CITY OF ALBUQUERQUE

November 19, 2021

**RE: Sandia Peak Grid BESS Facility
Conceptual Grading and Drainage Plan
Engineer's Stamp Date: No Date
Hydrology File: D16D002A9**

Based upon the information provided in your submittal received 10/18/2021, the Conceptual Grading & Drainage Plan **is not** approved for action by the DRB on Site Plan for Building Permit. The following comments need to be addressed for approval of the above referenced project:

ABLE GRID	JOB NUMBER	REV
SANDIA GRID PROJECT	172221	B
PRELIMINARY GRADING AND DRAINAGE PLAN	DRAWING NUMBER	C3-1

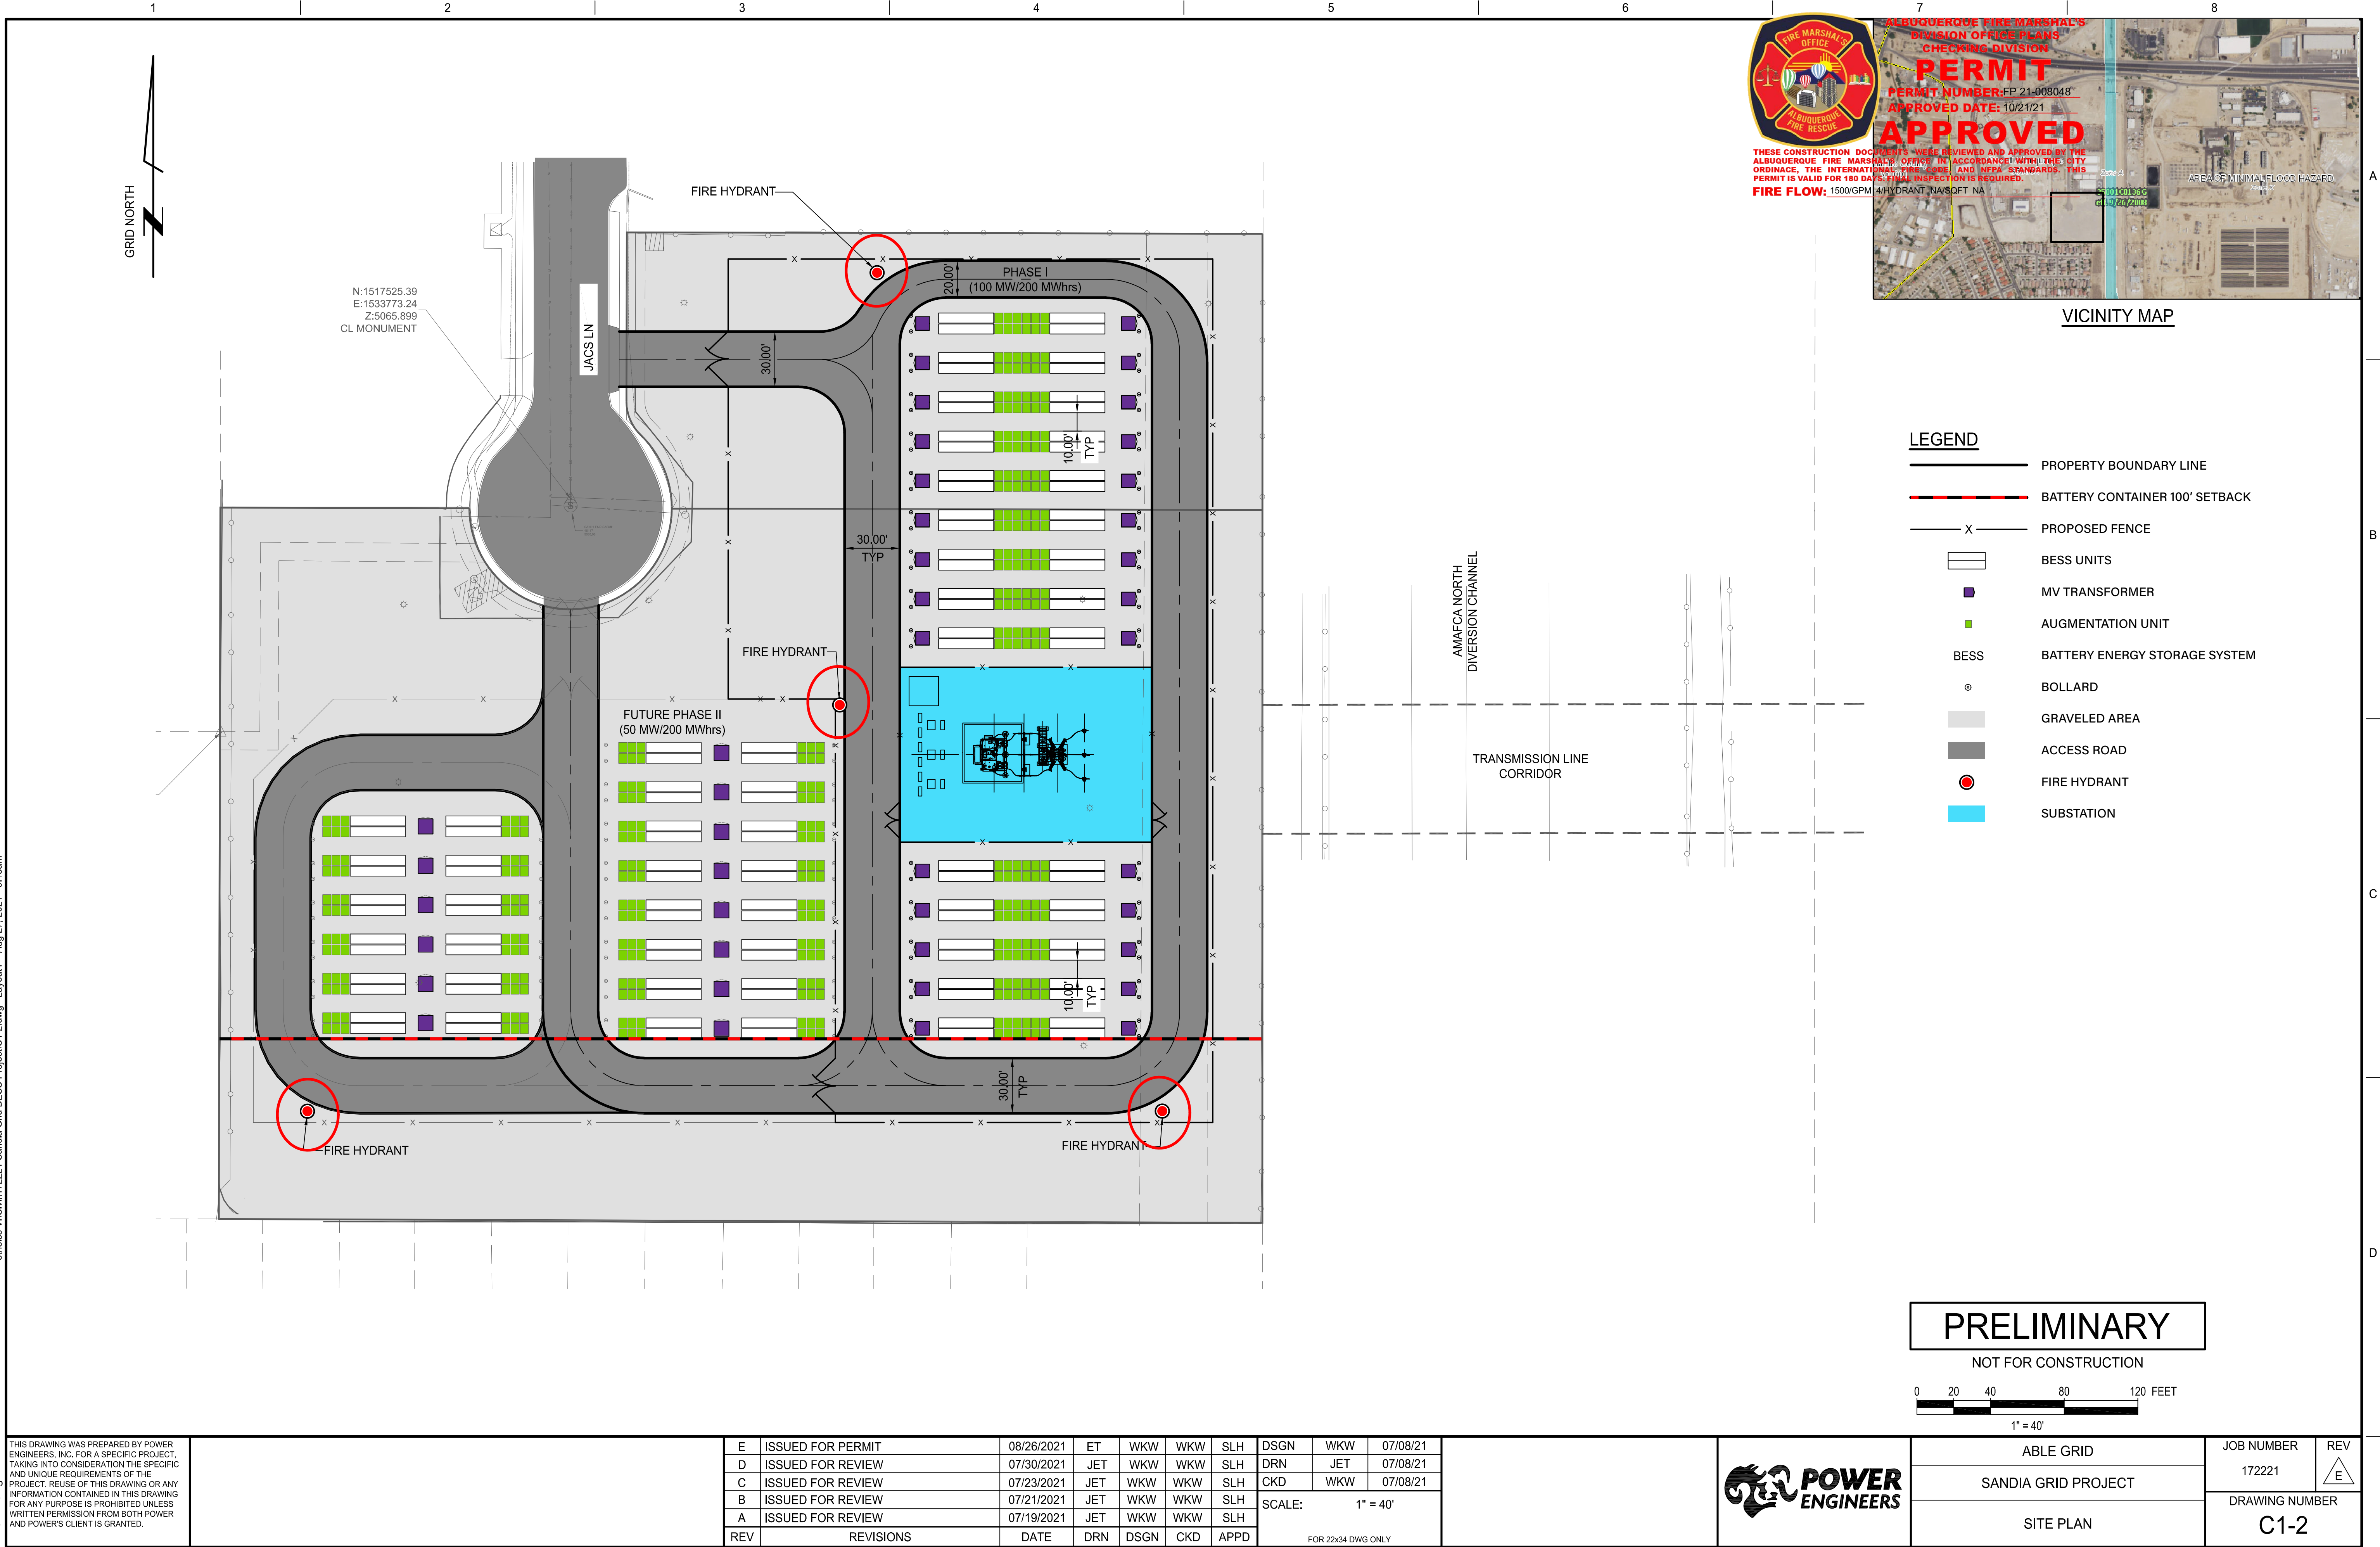
1. Please Per the DPM, the following must be on the Conceptual Grading Plan.
 - a. Please provide an engineer's stamp with a signature and date. Please note that this must be a New Mexico licensed civil engineer.

- b. Please label the grading plan "Conceptual and place a note, "Not For Construction" on the plan.
 - c. Please provide a Vicinity Map. See note #2.
 - d. Please provide the Benchmark information (location, description and elevation) for the survey contour information provided.

- e. Please provide the FIRM Map and flood plain note with effective date.
 - f. Please provide a legal Description of the property.
2. Provide a vicinity map showing the location of the site. Typically, this is the Zone Atlas. This can be downloaded in pdf format from the City of Albuquerque's website.

3. Please use the procedure for 40 acre and smaller basins as outlined in Development Process Manual (DPM) Article 6-2(a). Please provide both the existing conditions and proposed conditions for the 100 year-6 hour storm event.

4. Please follow the DPM Article 6-12 Stormwater Quality and Low-Impact Development for the sizing calculations. To calculate the required SWQV, multiply the impervious area draining to the BMP by 0.42 inches for new development sites.

5. Please label the SWQ pond with the provided volume.
6. Please add a note, "Side slopes need to be stabilized with Native Grass Seed (per City Spec 1012) with Aggregate Mulch or equal (Must satisfy the "Final Stabilization criteria" CGP 2.2.14.b.)". This is for the SWQ pond.
